# Building R1 (SSD 6513)

## Attachment A – Detailed Response to Submissions

Response to Schedule 1: Additional matters identified by the Department of Planning and Environment.

Elevation North

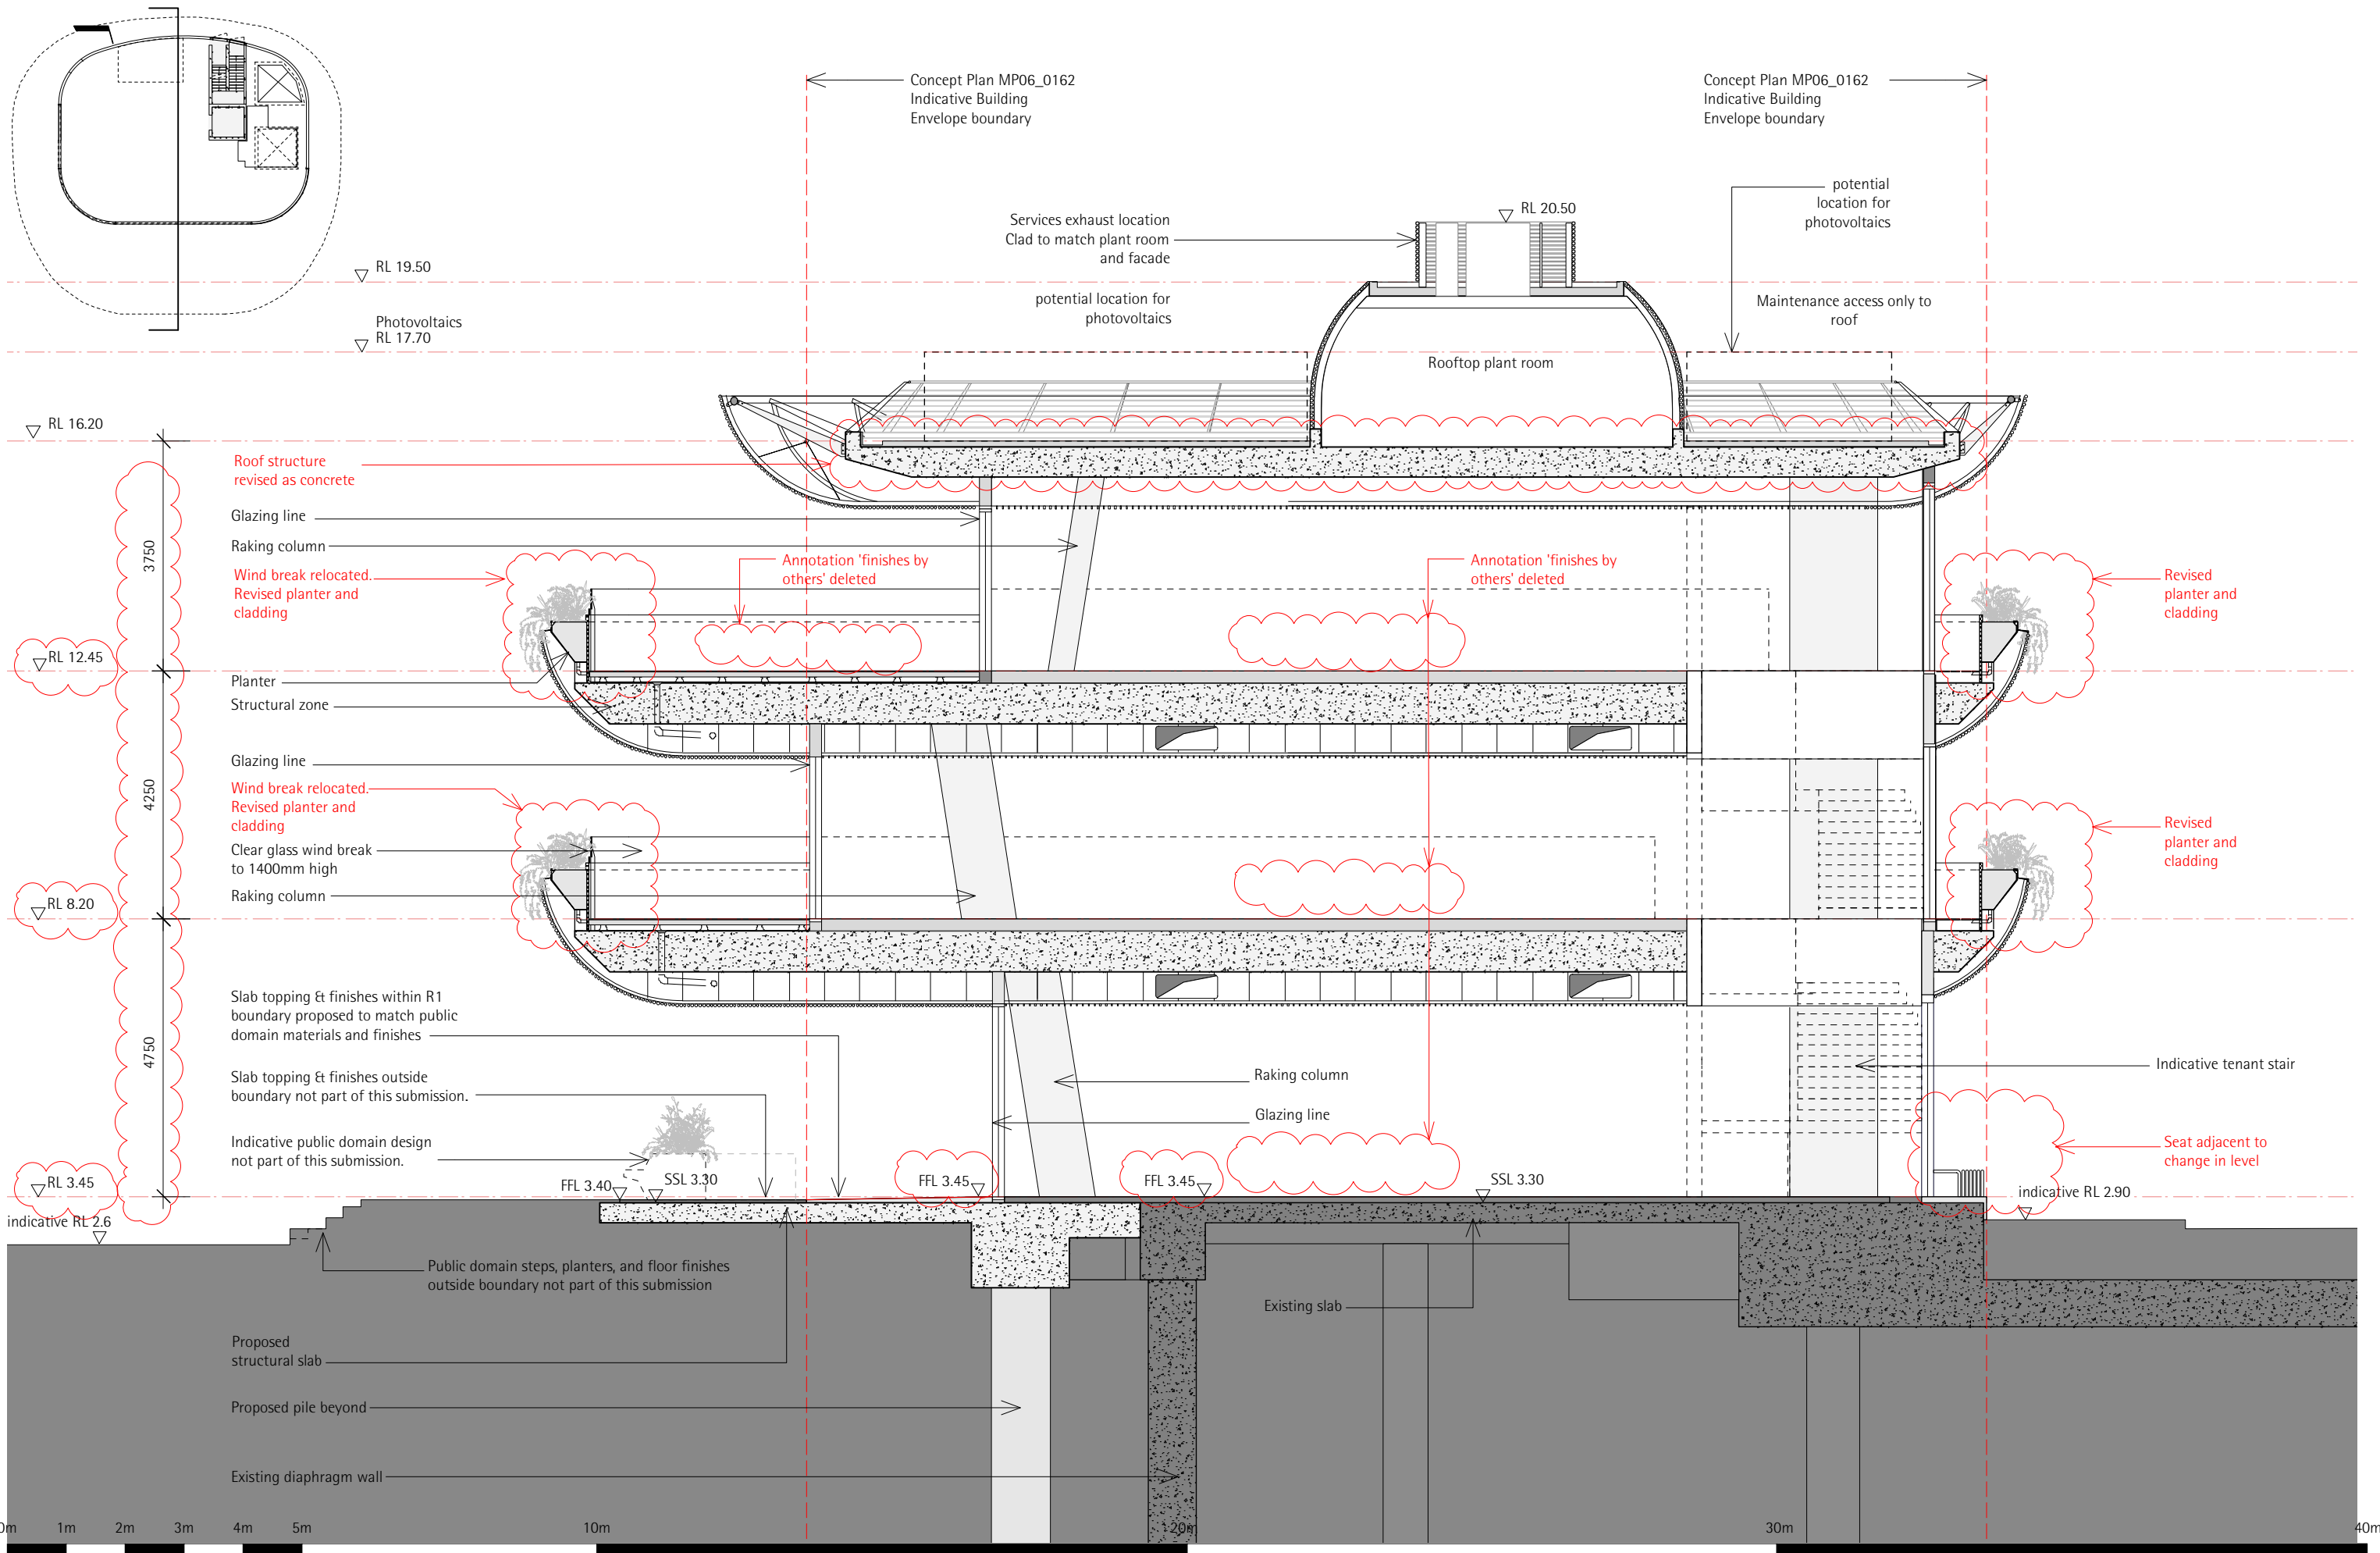
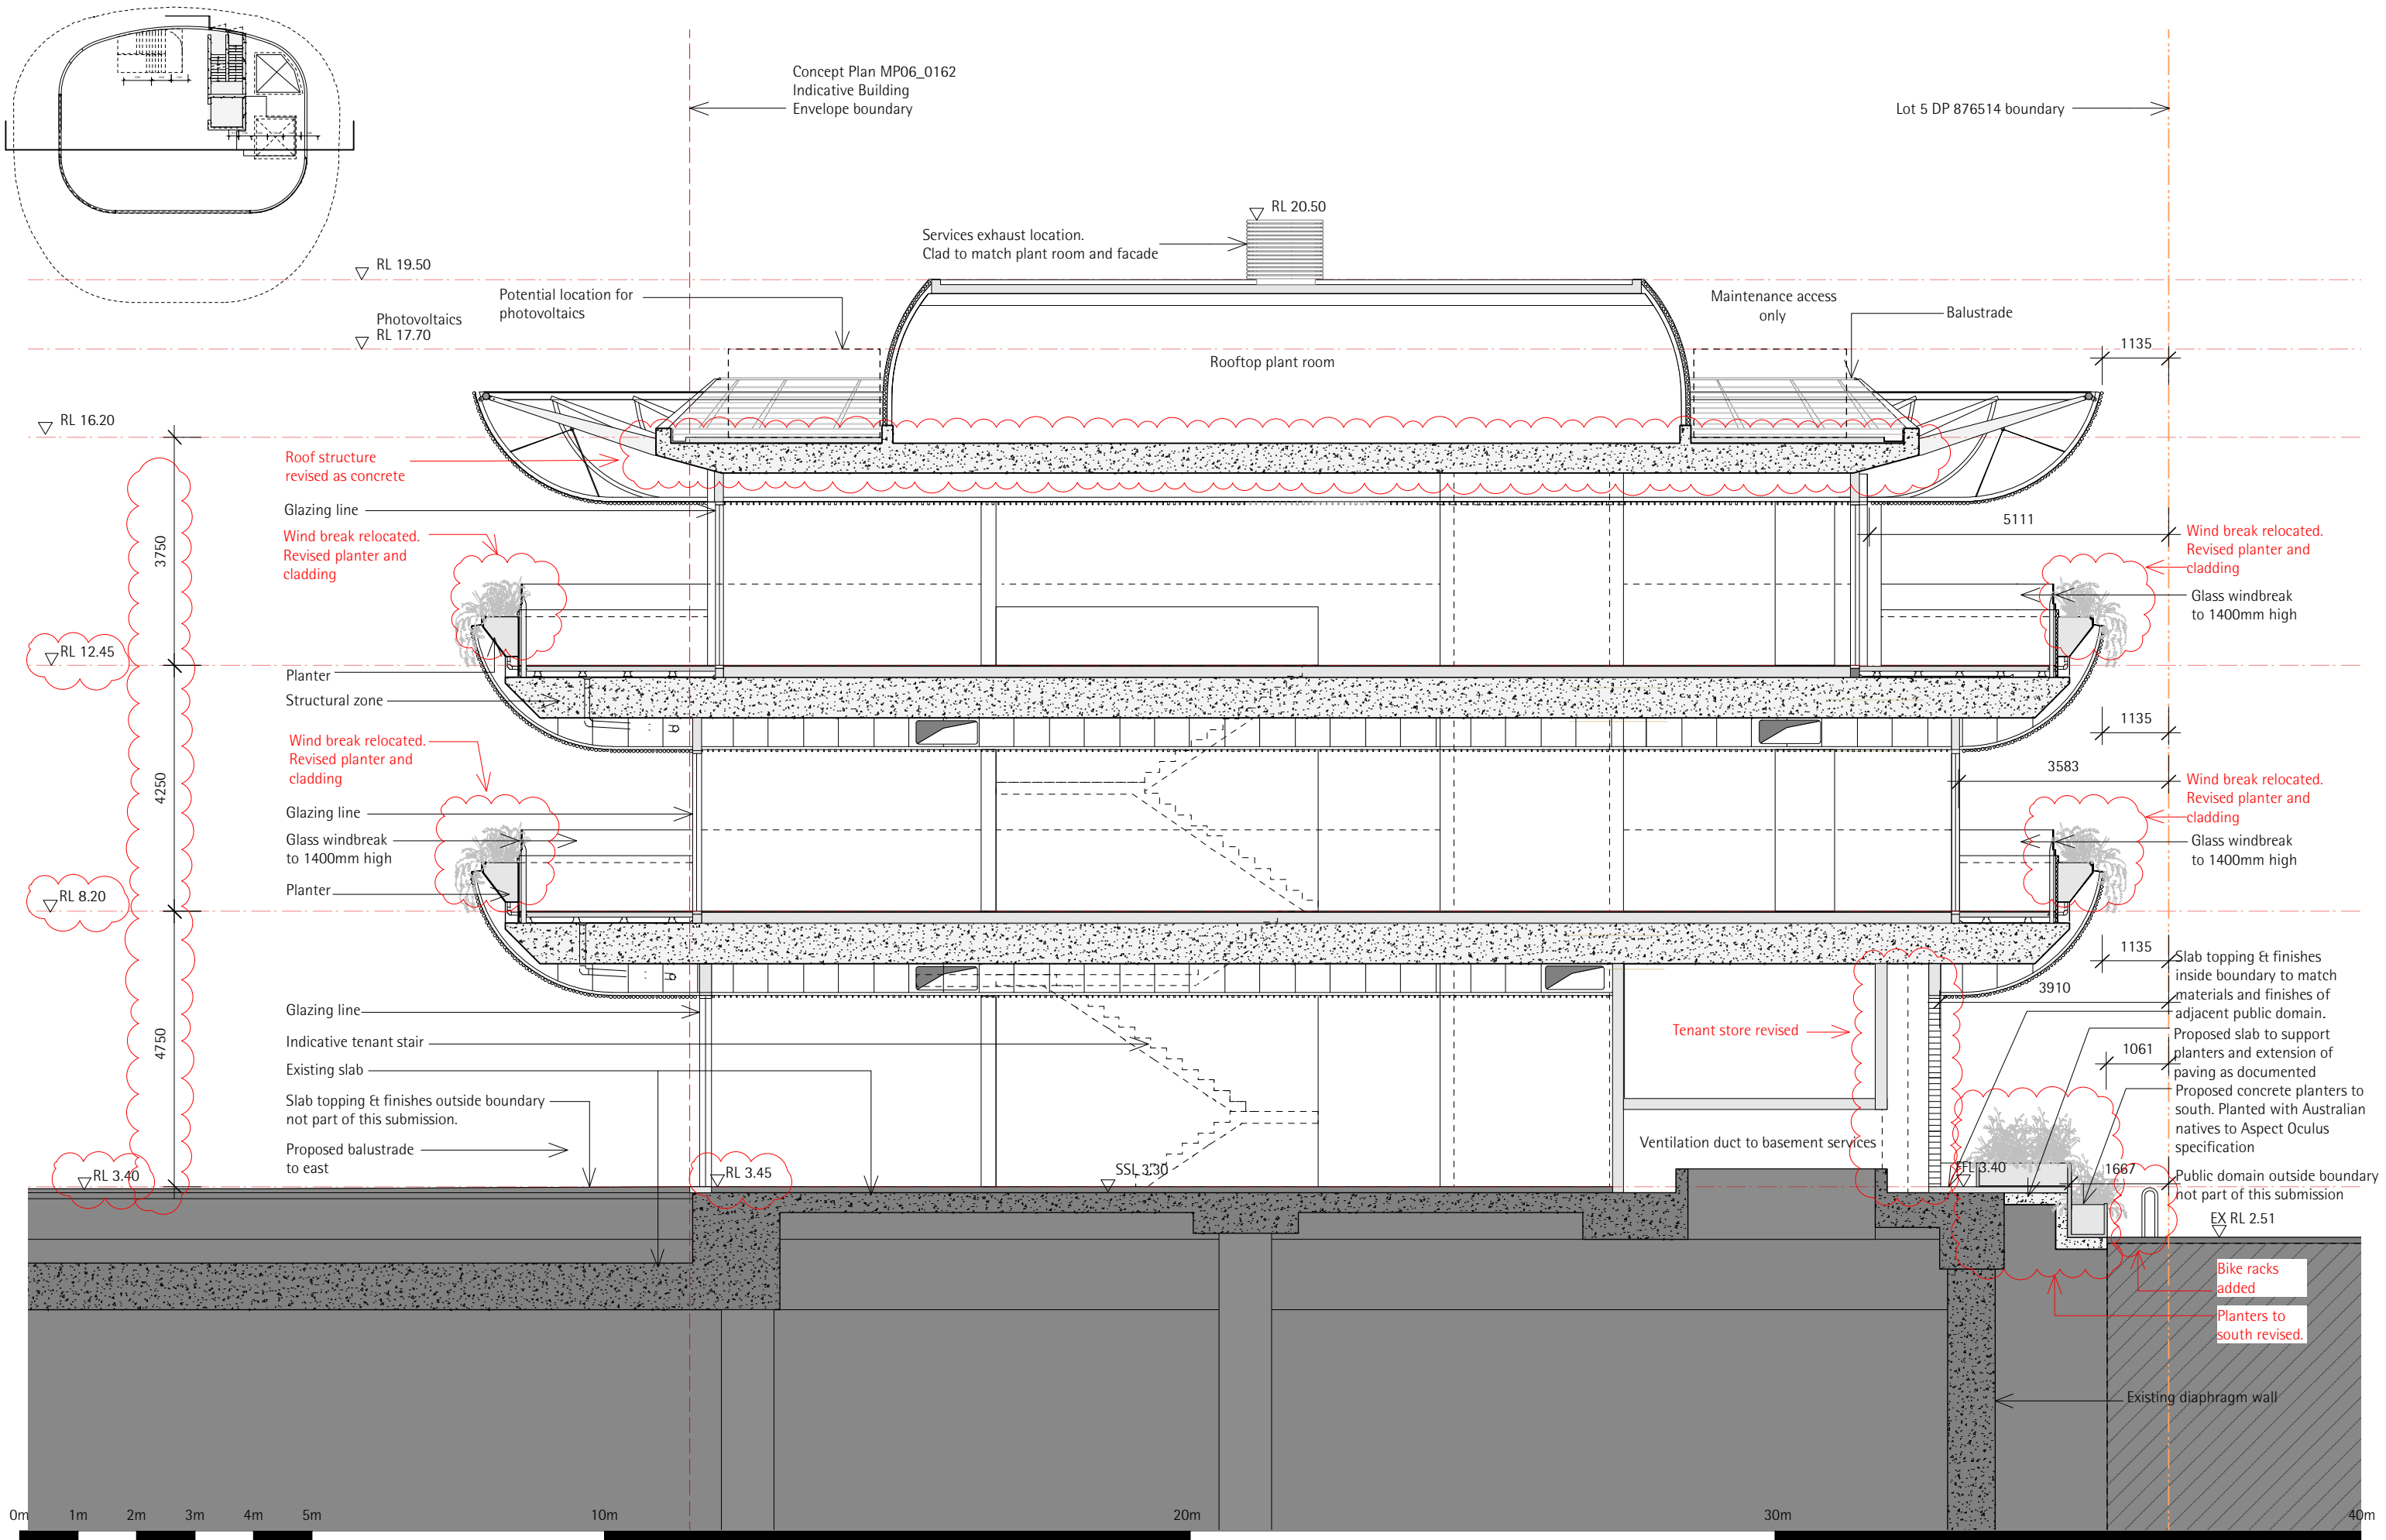
| Key Issues Raised |   | Lend Lease Response  |
|-------------------|---|--|
| 3                 | <p><b>Design Issues</b></p> <p>Although building R1 is conceived as an object building, to be experienced in-the-round, the ground floor uses and elevations to Lime Street and the south indicate largely blank, inactivated facades.</p>  | <p>A number of constraints exist for Building R1, including the need to accommodate the Shared Services Riser' which protrudes through to above-ground on the Building R1 site, and also the need to provide a services to support the building. The provision of services on the ground level is unavoidable and is common practice in all new developments. The location of these services has been contained to a small percentage of the façade. Through focusing these services to a small portion of the façade, it allows for a more contiguous and usable ground level that focuses the activation at the higher priority pedestrians areas of the Foreshore Promenade and Exchange Plan (formerly Transport Place).</p> <p>Careful landscaping treatments, including planter boxes, have been provided to soften the presence of these required services in the façade.</p> |
